Re: EP/47/19/HH

I am writing this correspondence in response to the recent letter from Kathryn Welch (Architectural Designer) Fuller Associates, regarding the second planning application submission for 11 Michel Grove. My points are as follows:

Street Scene
1:100

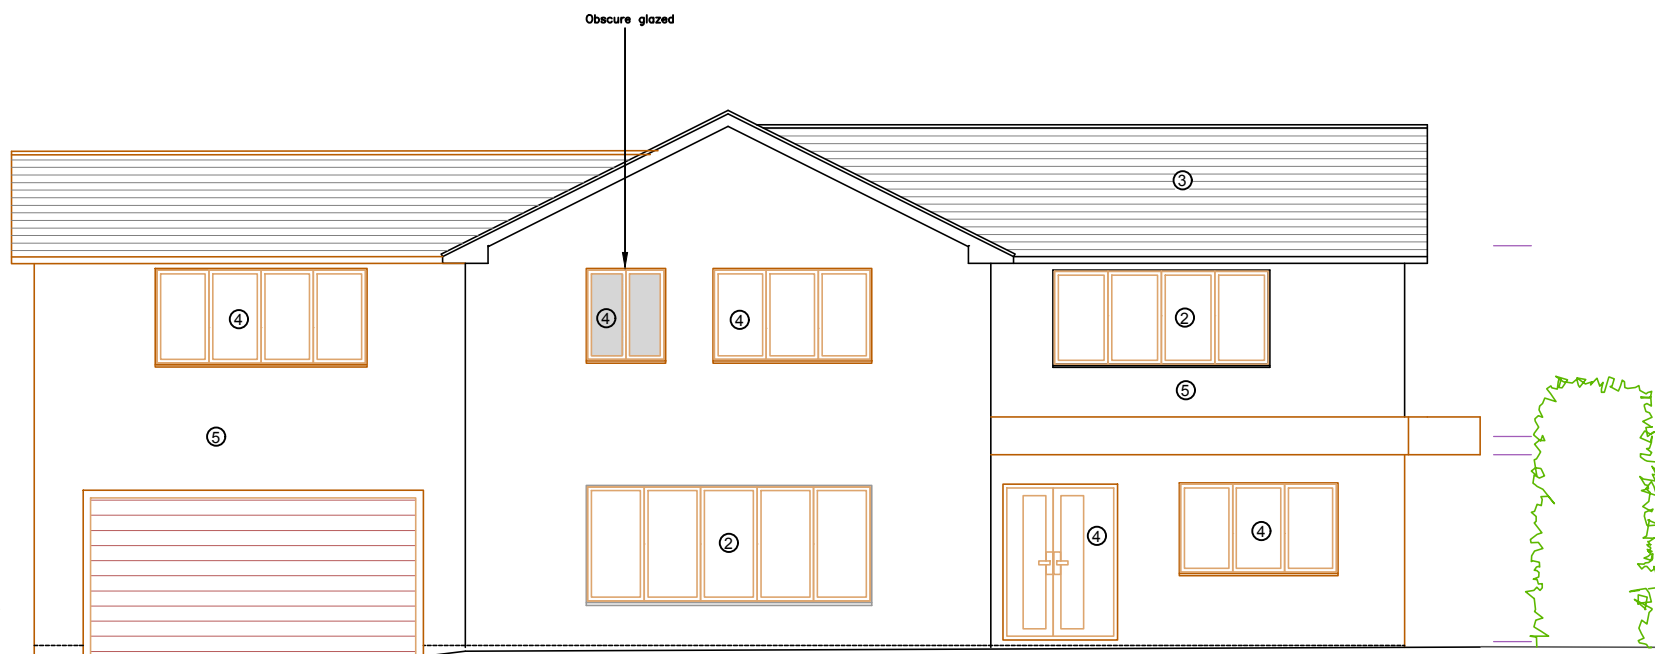
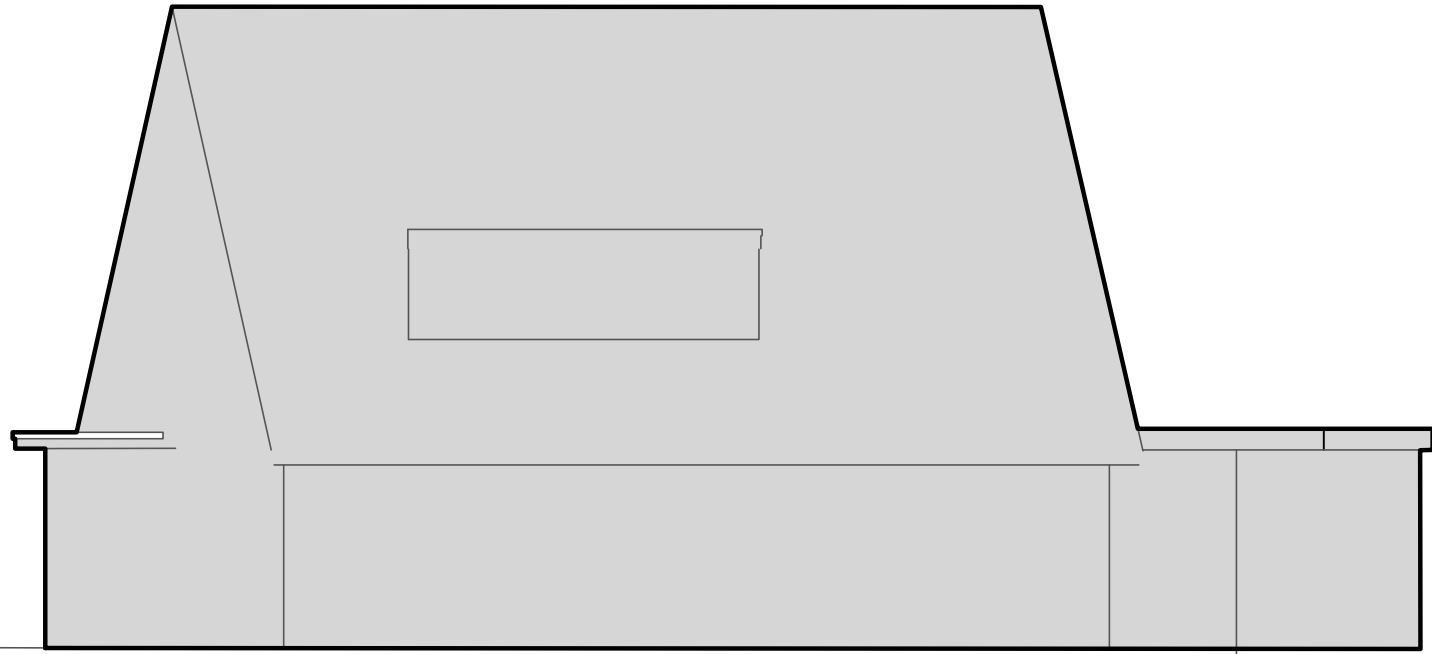
Both on this and the previous application, the applicant's agents had **several attempts** to produce a realistic image of the impact of this development. What they have produced is nothing more than a cartoon sketching and does not realistically demonstrate the **actual visual impact**, which has been provided with the Google Earth images. Ms Welch has made reference that the "*photomontage prepared by the neighbour at No.9 Michel Grove to be visually misleading and misrepresentative*", however, both Ms Welch and Fuller Associates have not produced any credible alternative which provides a **realistic visual image impact** of how this development will be viewed from the road. Let's be clear - It is the front of the property and the angle at which it is positioned on the site, which is the cause of the overbearing impact of this application for number 9 Michel Grove. Number 11 Michel Grove has been built diagonally on the site and this will always cause an issue for any further extensions to the front elevation of this property.

The street scene image provided by Fuller Associates presents a "visual gap" between number 11 and number 9. However, if you simply look at a front focused photo of number 11 and follow the proposed line of sight of the proposed extension – there is no physical way a visual gap will be present between the two properties. Number 11 will overlap the visibility of number 9. Disturbingly, my assumptions can also be witnessed on the architectural drawings which Fuller Associates have produced and submitted as part of this application. Please cross reference the "overhead proposed plot image" against the "street scene" drawing. There is no physical way the street elevation drawing, with a gap between the properties, aligns to the overhead plot image drawing. The gap does not exist.

PROPOSED FLOOR PLANS

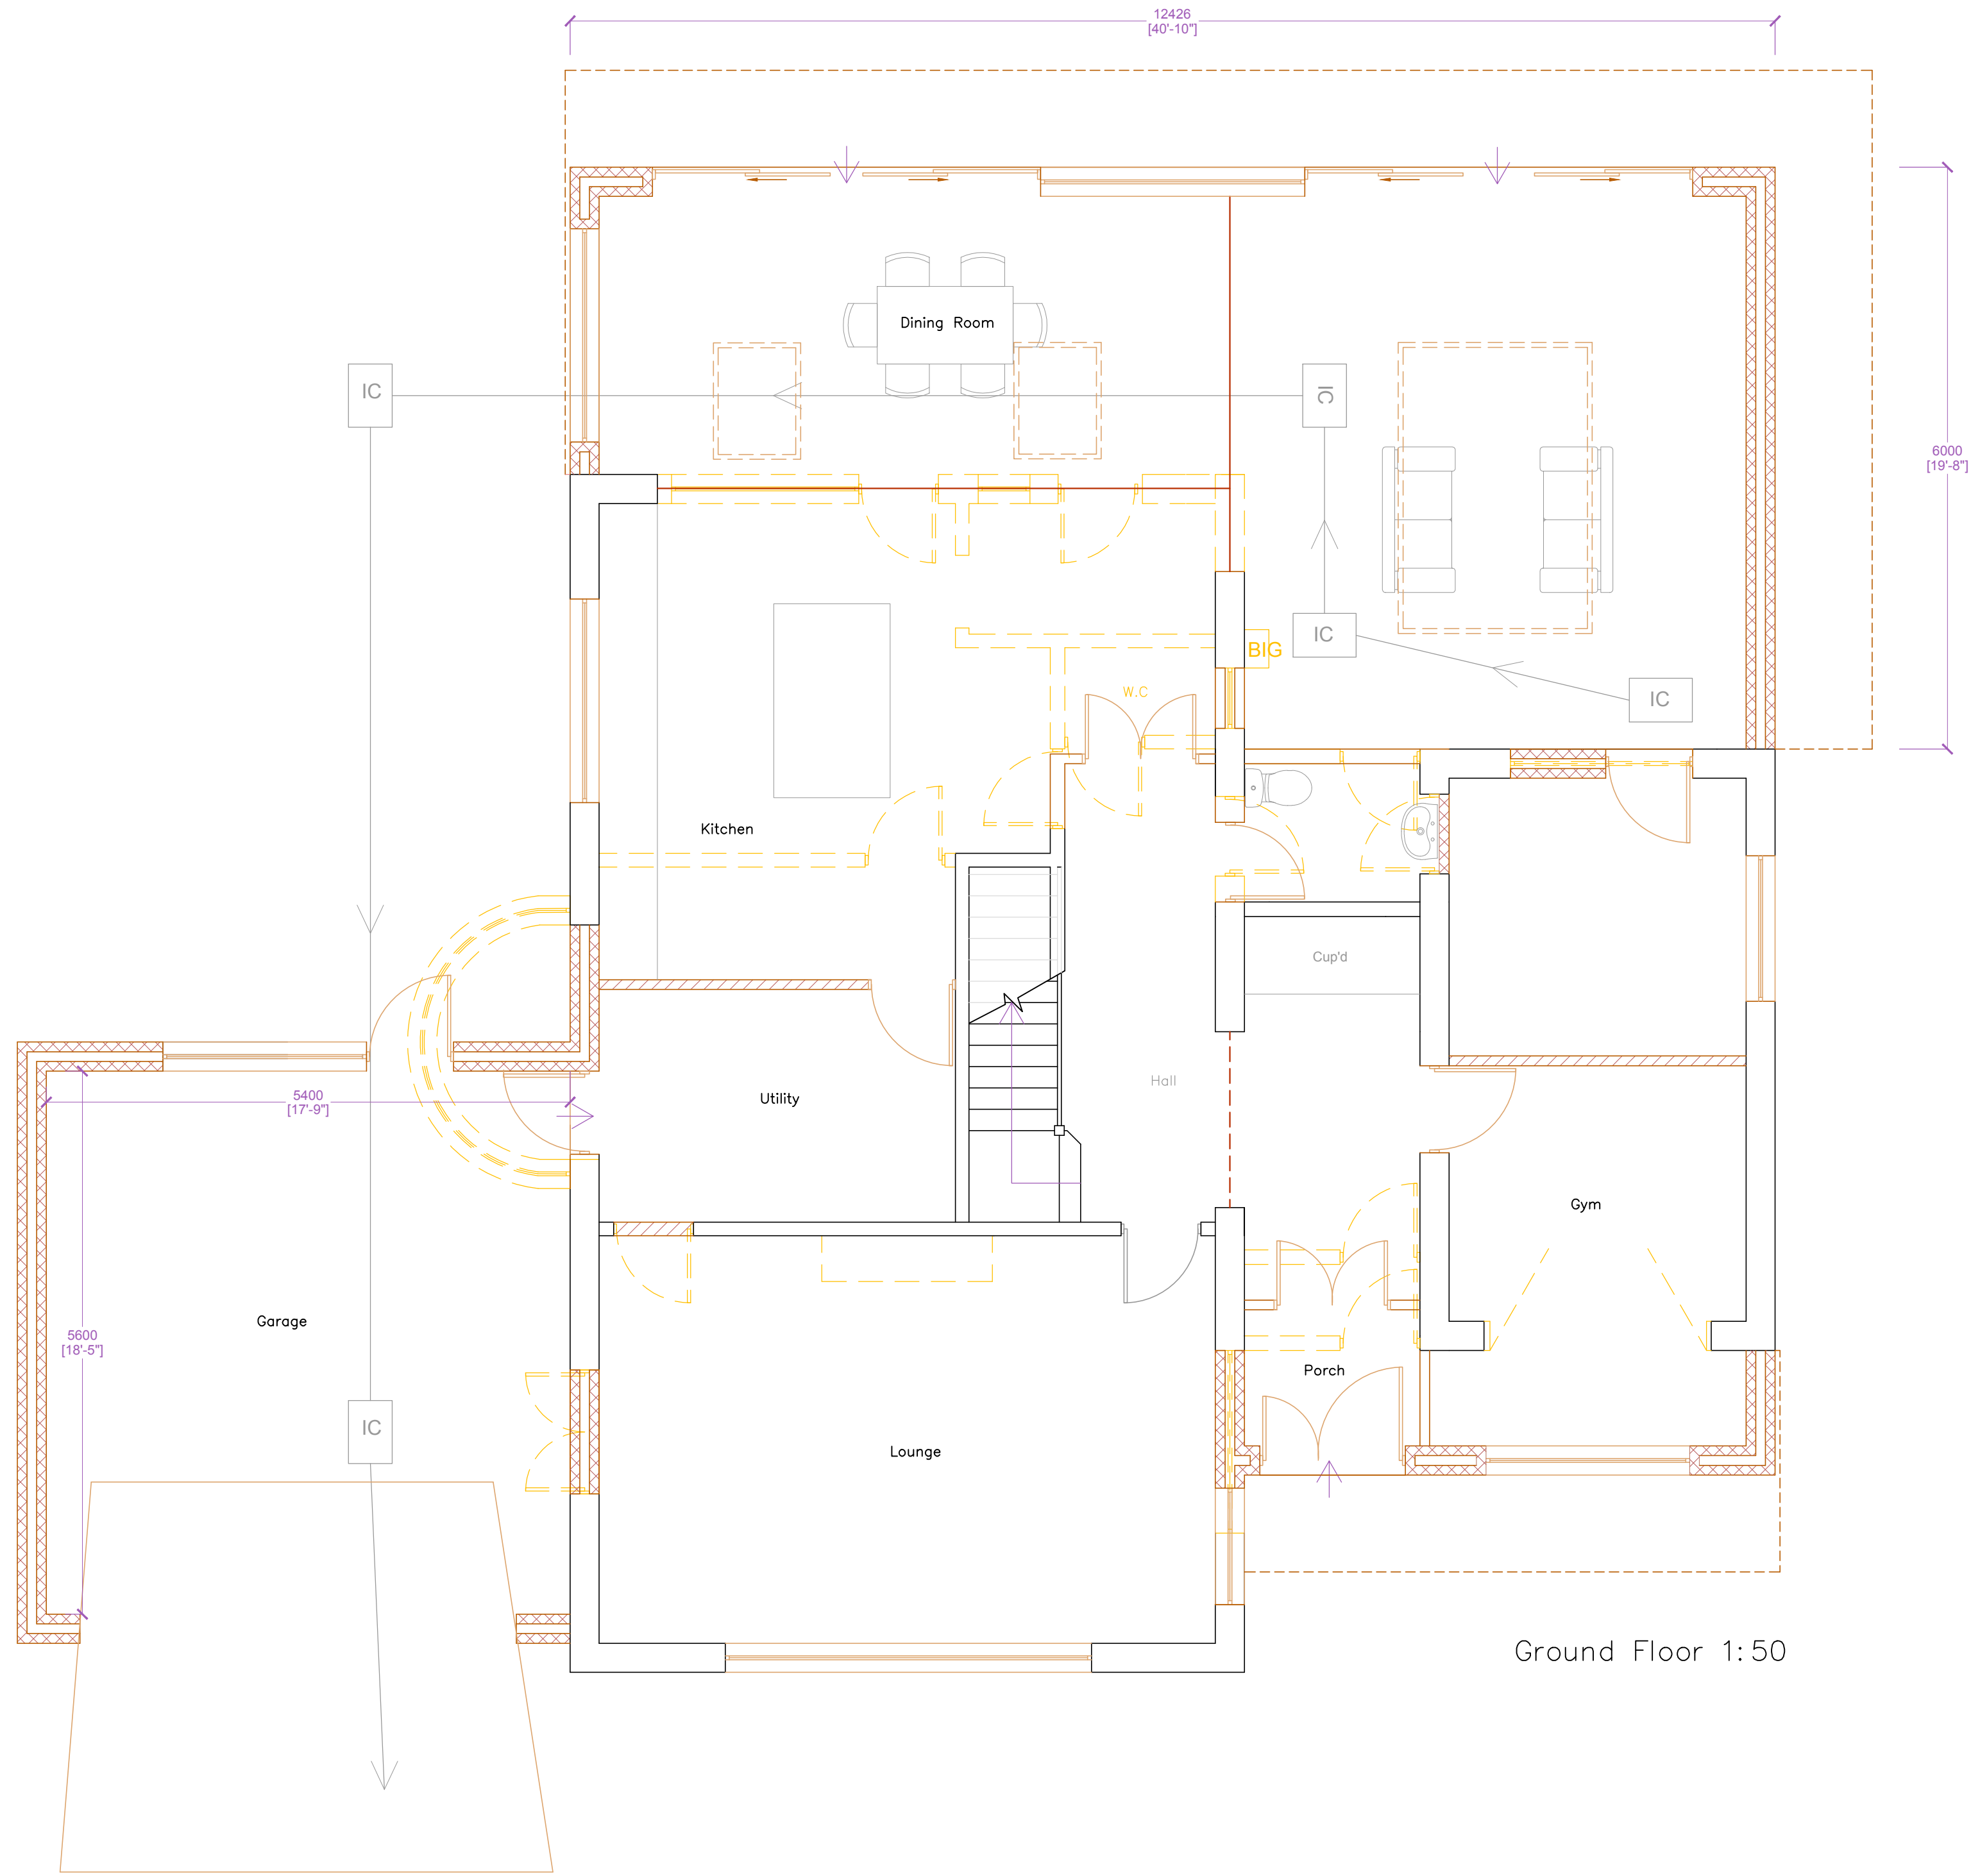
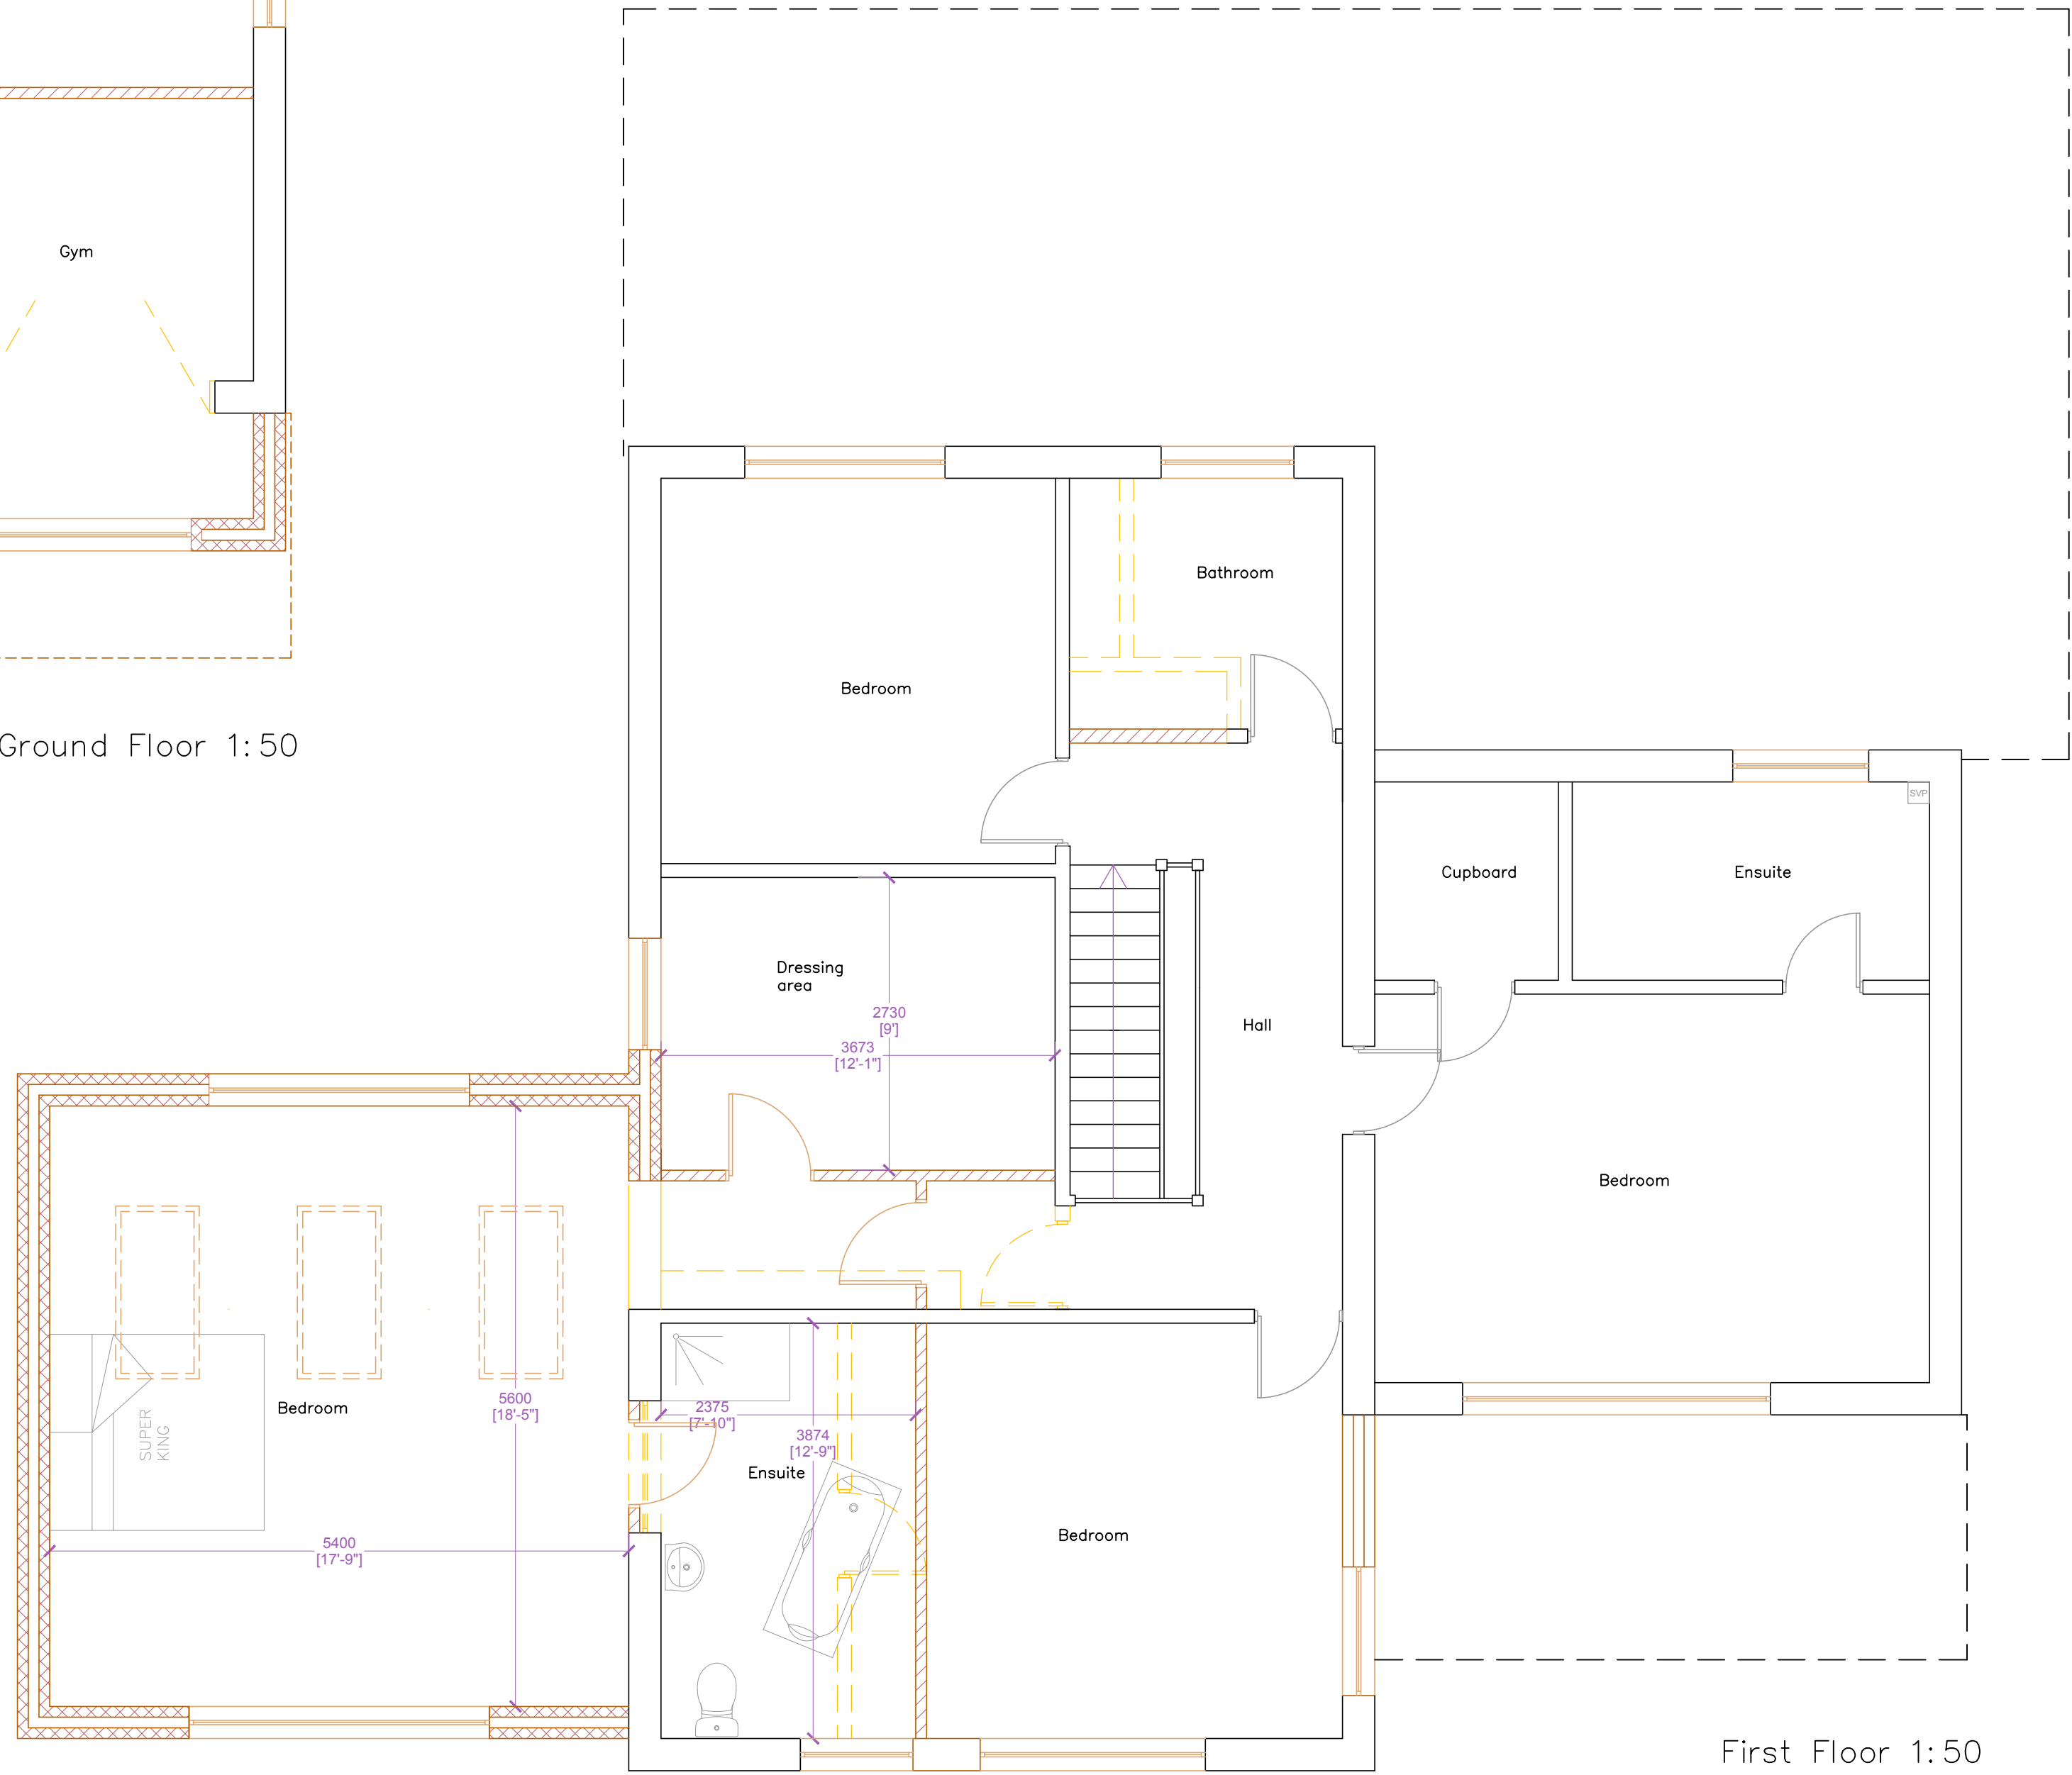
Let's also take this back this back to basics for Ms Welch. The property is currently a 4 bedroomed property and this is how this was marketed when the property was sold to Mr & Mrs Harding in June 2017. The additional rooms added to the property, under both application submissions, have been as follows:

(1) A Dressing room

(2) A Gym

(3) A Dining Room

(4) A Second Lounge adjacent to the new dining room (un-named on the plans- but has two sofas).

How these rooms are “being named” for the application process, cannot guarantee that this would remain in practice post build or when/if this property was to be ever marketed again on the property market. Looking at the dimensions of both “*the dressing room*” and “*the gym*”, at a minimum, could both be regarded as **two additional bedrooms**. Therefore, this could be regarded as a six bedroomed residence and not four, which Ms Welch stands by in her opening statement.
